Inspector's Report ACP-322823-25

Whether the placement of roof, install windows and doors and apply external render is or is not development or is or is not exempted development.

Mongfune, Murroe, Co. Limerick

EC/106/25

- Placement of roof
- Installation of windows & doors
- Application of external render

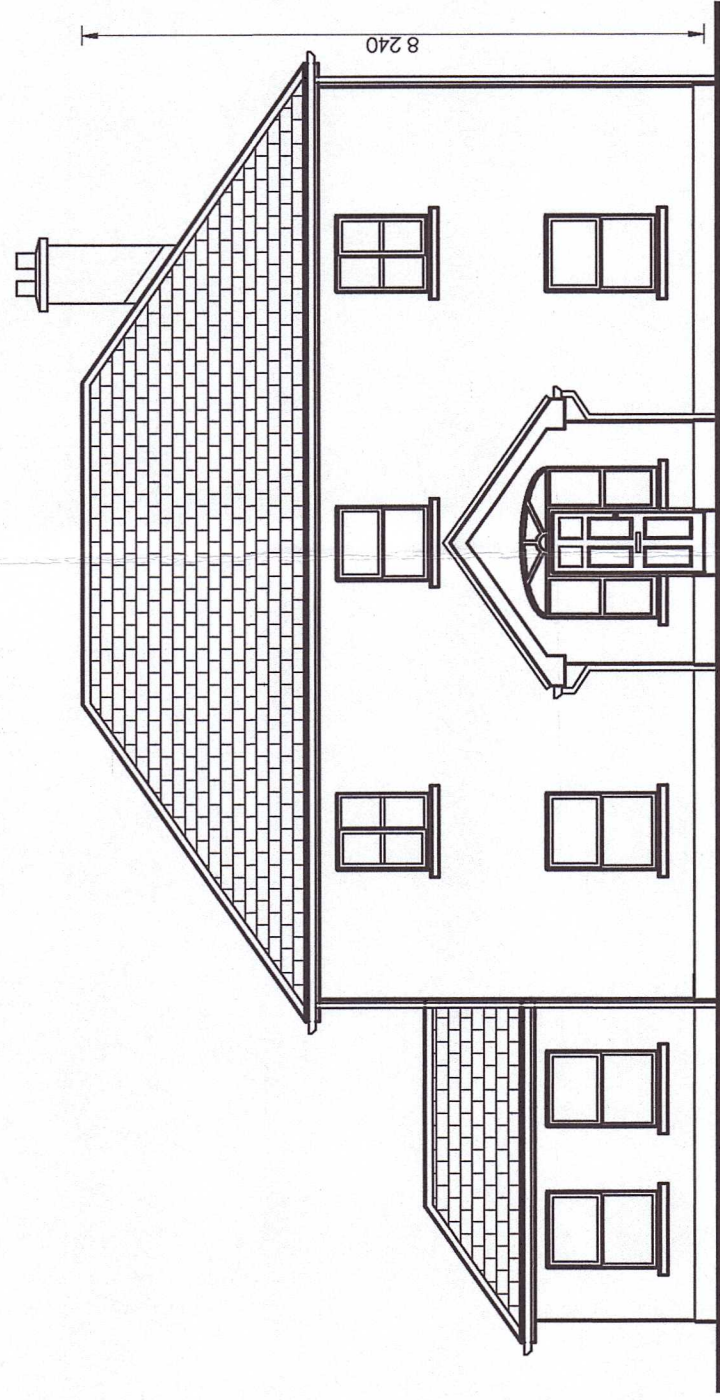
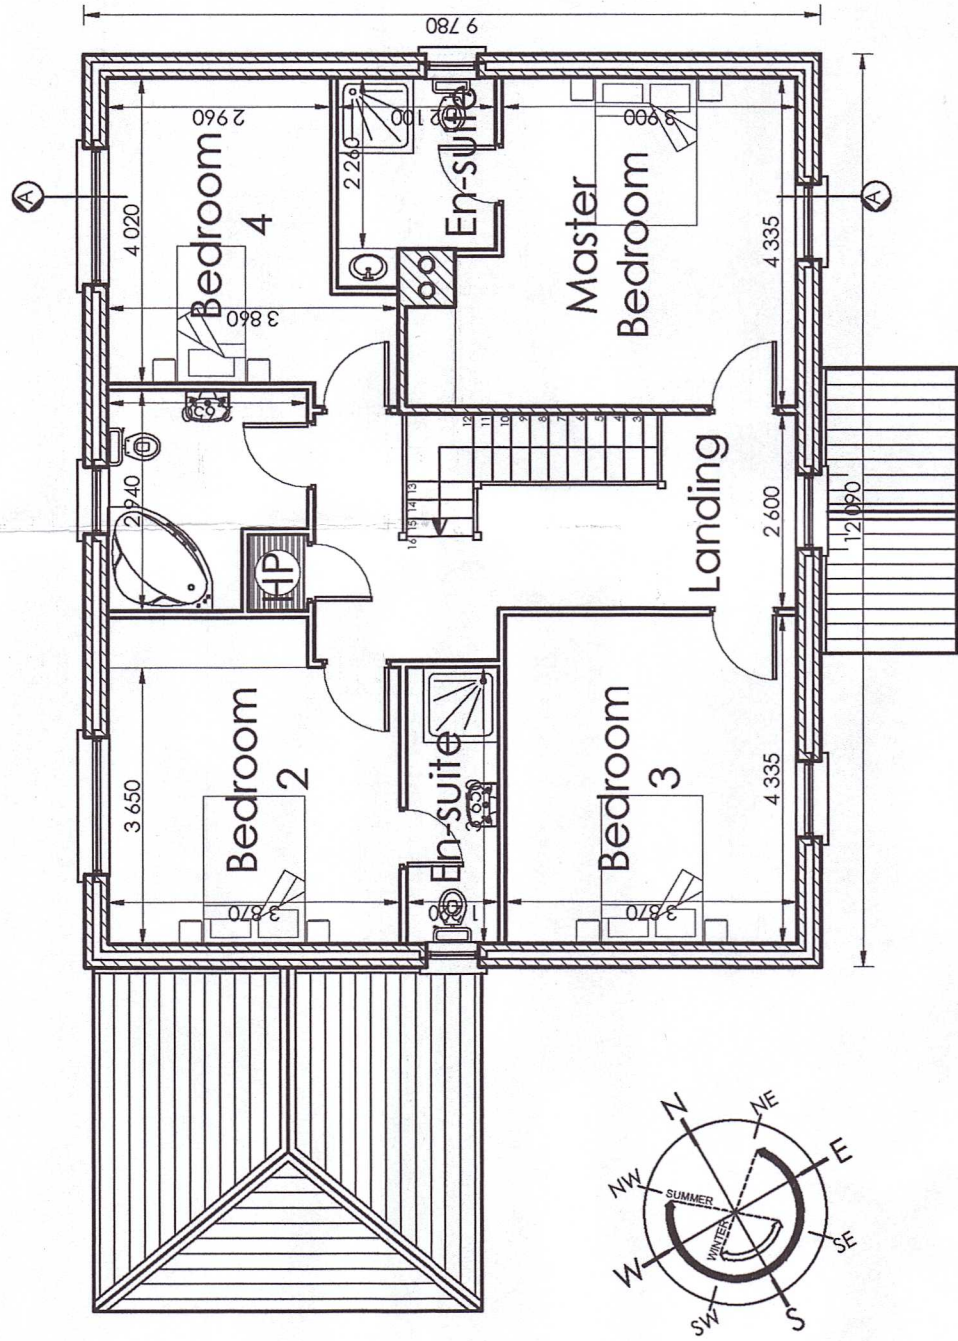
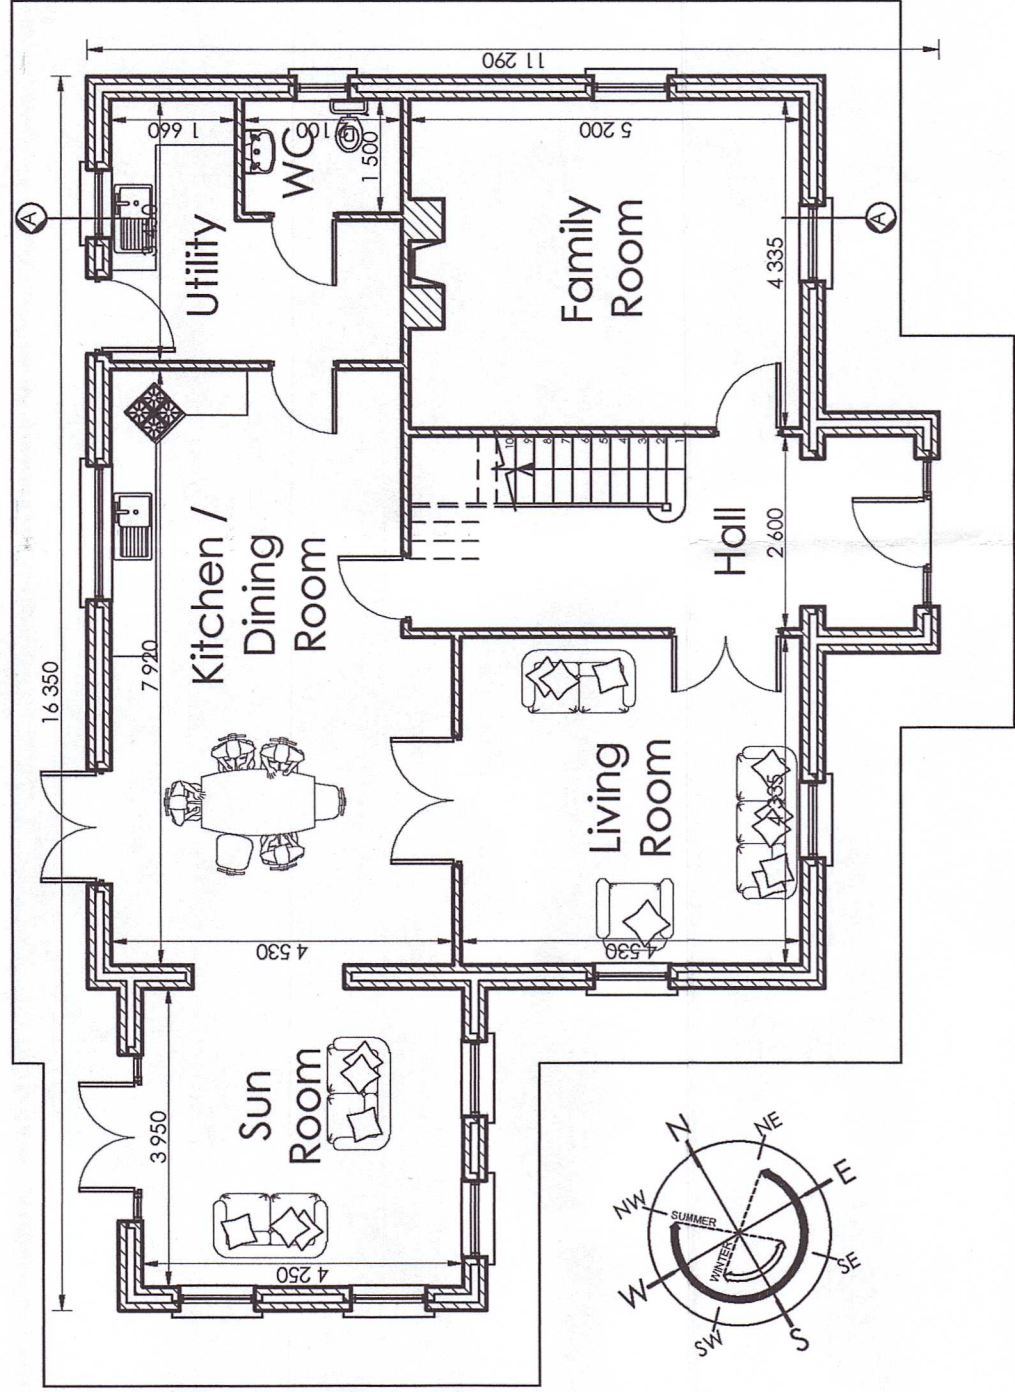
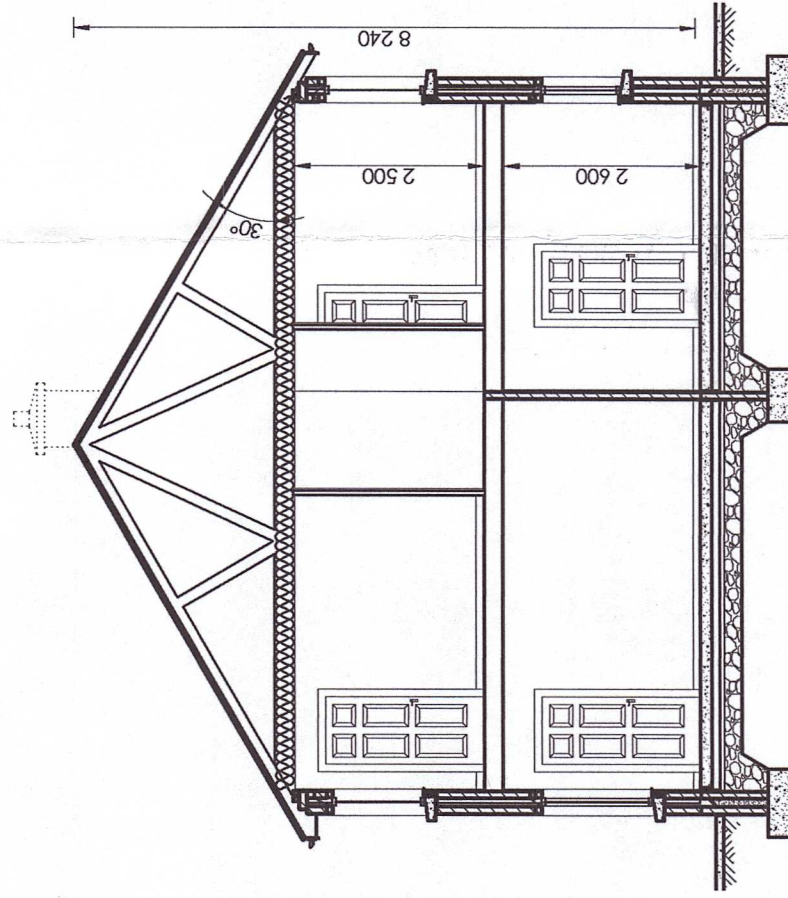
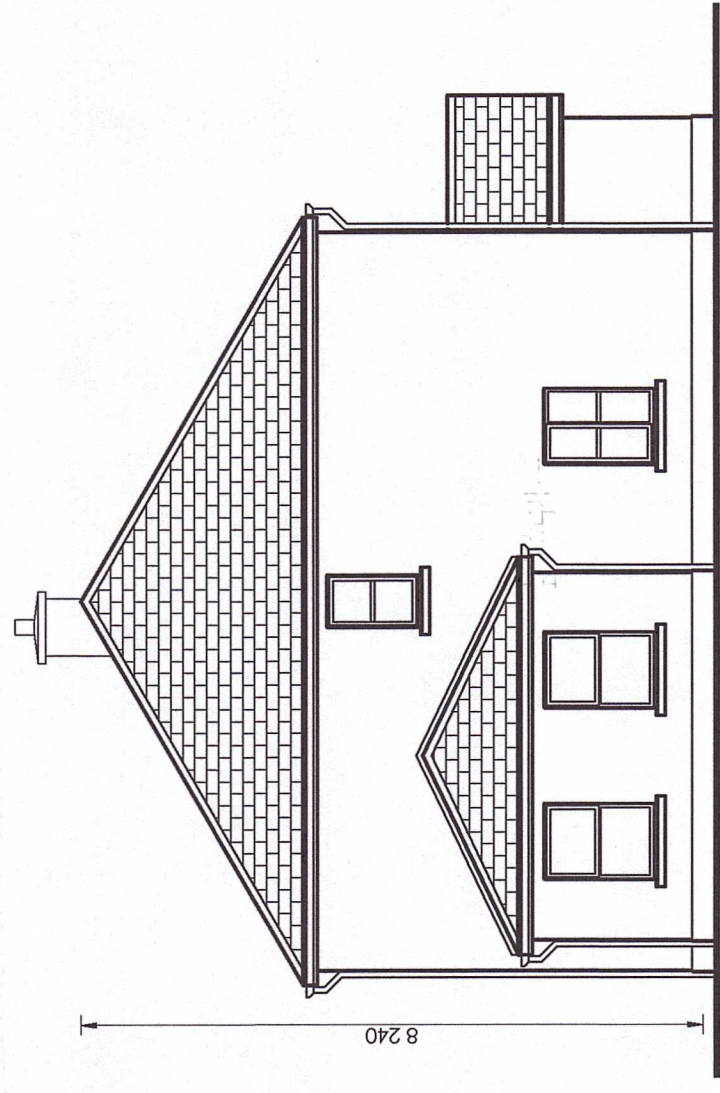
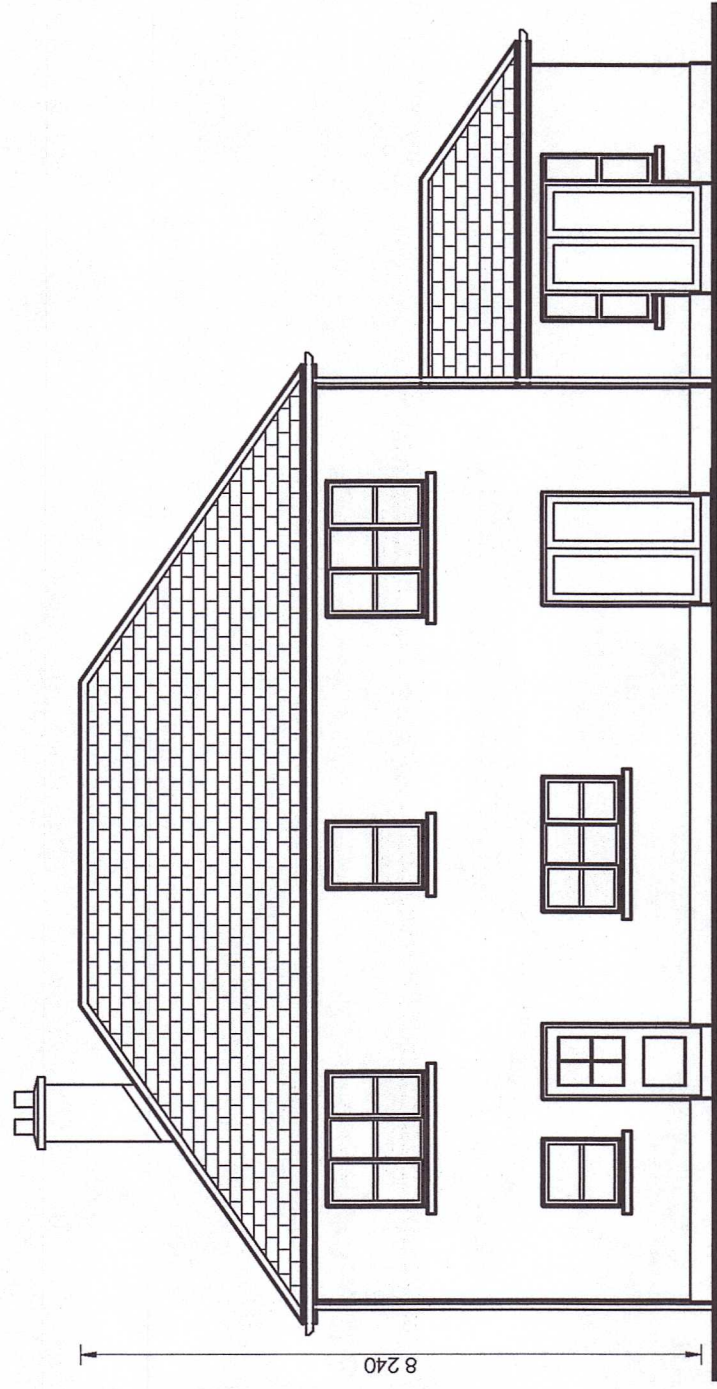
- 9.1.4. The planning officer further describes the existing structure as comprising a single storey extension to the rear of the existing dwelling. This is not accurate as I note from the plans and drawings submitted with the referral appeal and from site inspection that there is no such extension constructed at the rear of the existing structure. There is however a single storey element constructed to the side (southern elevation) and having regard to the details on the file, I note that this relates to a sunroom.

- 9.3.2. The question at issue is whether or not the development proposed would materially affect the external appearance of the existing structure so as to render the appearance inconsistent with the character of the structure or with neighbouring structures.

- 9.3.3. In the first instance, the existing structure is not a completed structure. I refer the Commission to the meaning of a ‘house’ and ‘habitable house’ under Section 2(1) of the Act. From my site inspection, it is clear that the existing structure on the site is the shell of an incomplete dwelling, and it would appear that works already carried out are similar to that permitted under P.21/695. In my view the existing structure on the site requires substantial works to be carried out in order for the structure to be completed, to enable it to be habitable and consequently, to allow for it to be occupied. I would note also that the wastewater treatment system to serve the dwelling and the proposed entrance are not in place.

- (a) The subject structure is incomplete and consequently was never occupied and is therefore not a 'habitable house', as interpreted under Section 2(1) of the Planning and Development Regulations 2001 (as amended),
- (b) The proposed works which include for the placement of roof, install windows and doors and apply render constitute development within the meaning of Section 3 of the Planning and Development Act 2000 (as amended);
- (c) The said development is not exempted development, as the works described cannot avail of an exemption under Section 4(1)(h) of the Planning and Development Act 2000 (as amended) due to the existing structure being incomplete and therefore not being a 'habitable house'.

NOW THEREFORE An Coimisiún Pleanála, in exercise of the powers conferred on it by Section 5 (3)(a) of the 2000 Act, hereby decides that the placement of roof, install windows and doors and apply external render is development and is not exempted development.
